**From:** [Redacted]  
**Sent:** 08 June 2010 08:18  
**To:** Planning  
**Subject:** Re Case 932 - Attn Miss J Phillips  
**Attachments:** 42DCPlanning.doc

**Erection of first floor side extension, single storey rear extension with conservatory and formation of front door canopy at 42 Daffodil Close HATFIELD – Case 932**

PROPOSED FIRST FLOOR PLAN

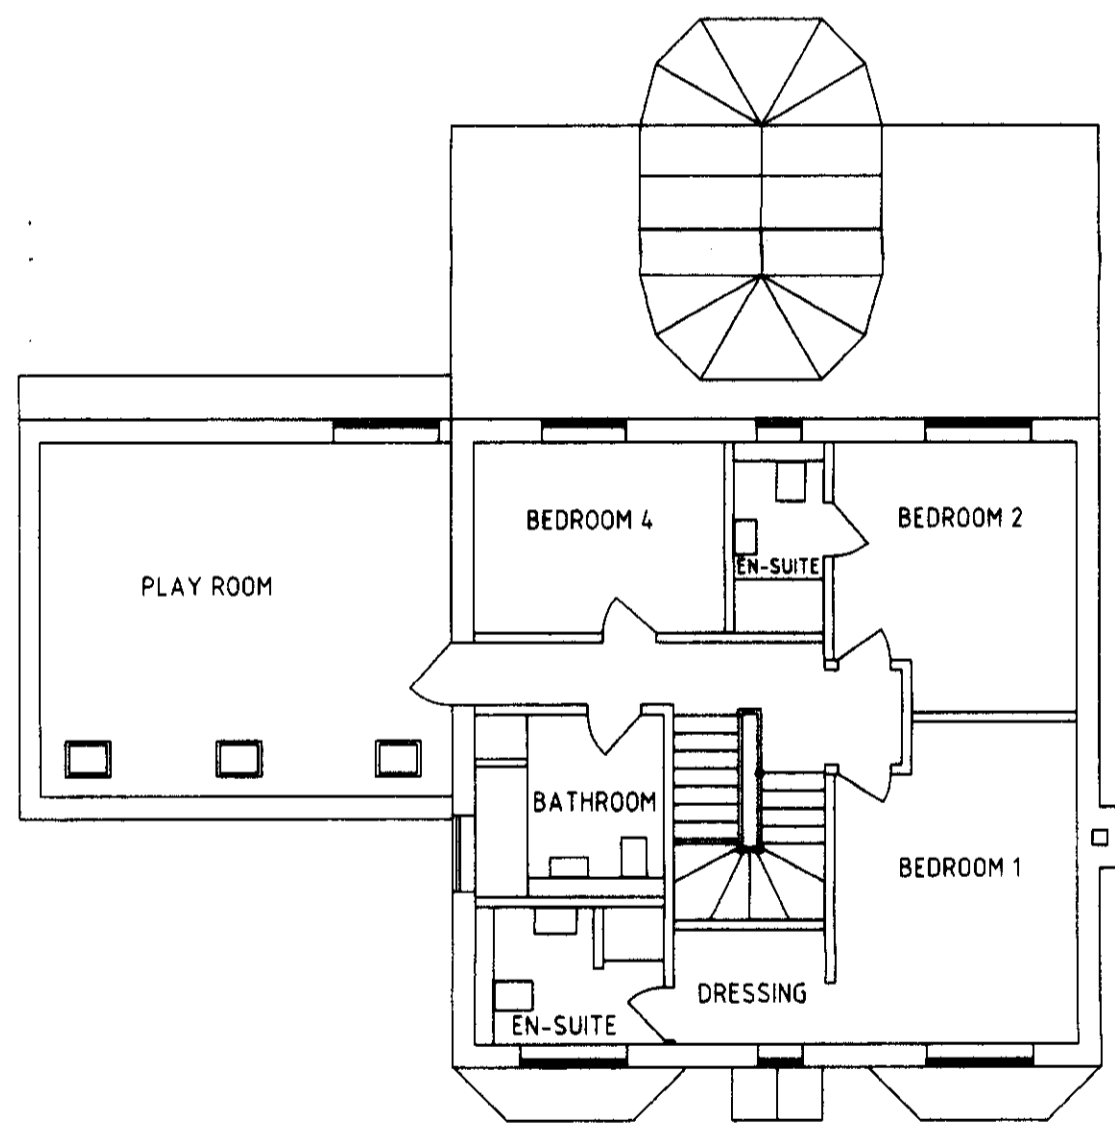
- This will provide a very unsightly view for our garden, having in effect a double storey brick wall bordering a large percentage of our garden. We feel that the

addition of the window will provide a direct view over our entire garden, which is not possible elsewhere in the surrounding houses and intrudes on our privacy.

- We were led to believe when purchasing our house that the development was not permitted to have existing garages developed over them, which was fundamental in the selection of our plot.
- The loss of natural light in the morning will be very noticeable
- This extension is for the purpose of 'a playroom'. We are concerned that this can easily be utilised as a bedroom given its size and question why a temporary or permanent solution such as converting garage space has not been considered as in other homes on the development
- The Dutch gable design at the front of the house and non-use of dormer windows really detracts from the design of the original development
- We feel again that such an imposing extension has the ability to deter future purchasers of our home

PROPOSED REAR ELEVATION

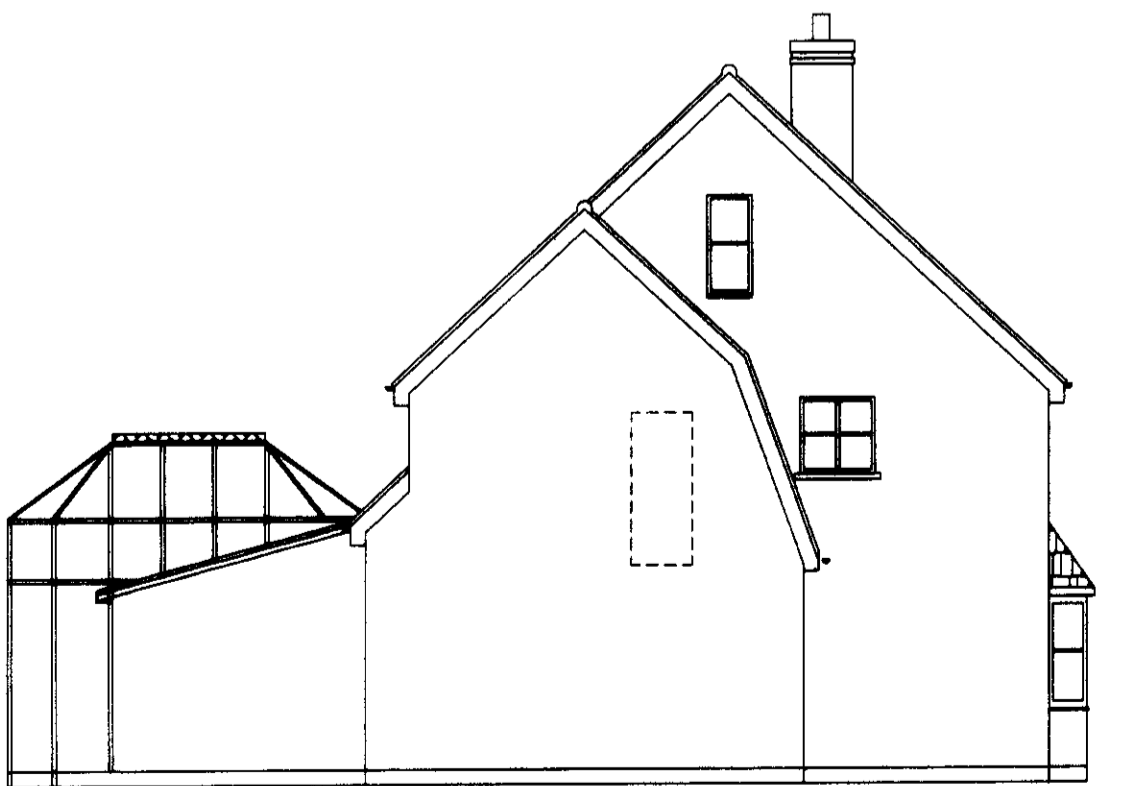
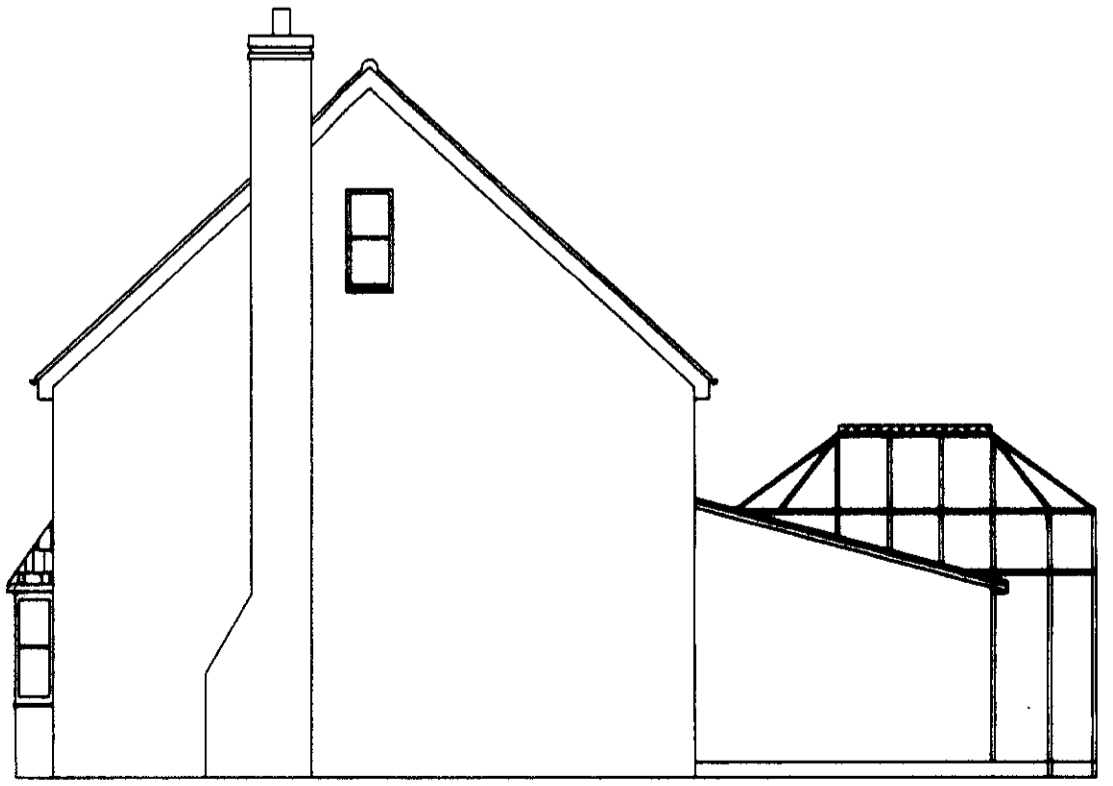
- This extension to the property is extremely and unnecessarily high, especially the conservatory element, and large in size which will be exceptionally visible from both our lounge and main bedroom windows.
- As the extension is south facing we anticipate that our house will receive unwanted glare or reflection from the mass of angled glass.
- We feel that having such an out of keeping view, indeed blocking view of the countryside from our main bedroom window and sight of the glass structure will detract future house purchasers, not only for us but others
